**Consultation Response from KC,
Trees**

2025/90862 Land Adj, 26, Track Lane, Batley, WF17 7AA

Erection of detached dwelling

Date Responded: 25/04/2025

Plan Title: Tree Impact Plan

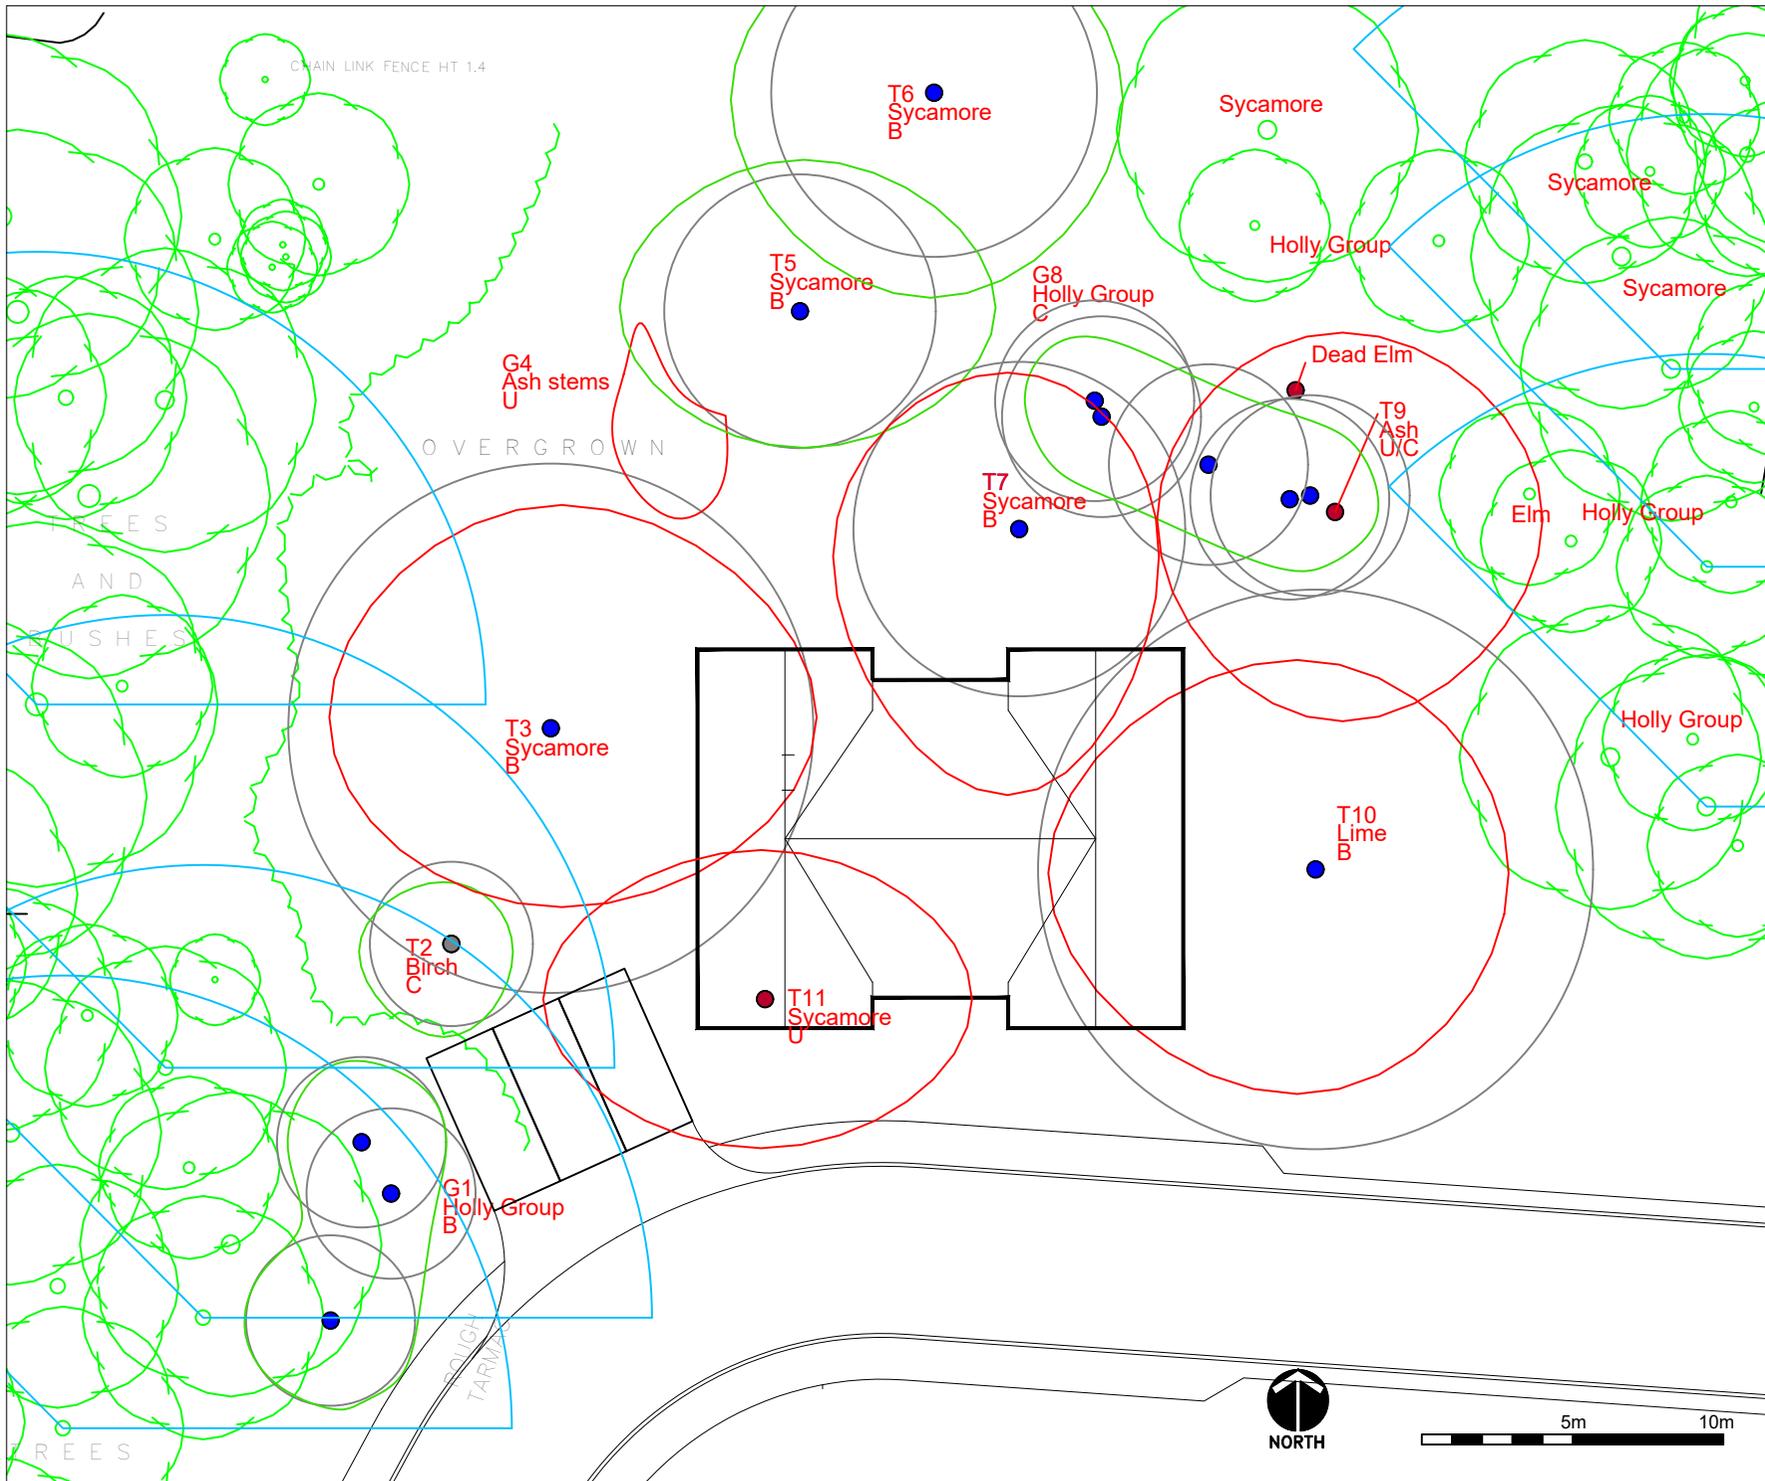
The removal of TPO trees, protected for their public amenity cannot be supported for the construction of a single dwelling.

There is an objection from an arboricultural perspective. The proposal conflicts with adopted Kirklees local plan policy 33 and 24 (i). Please see below:
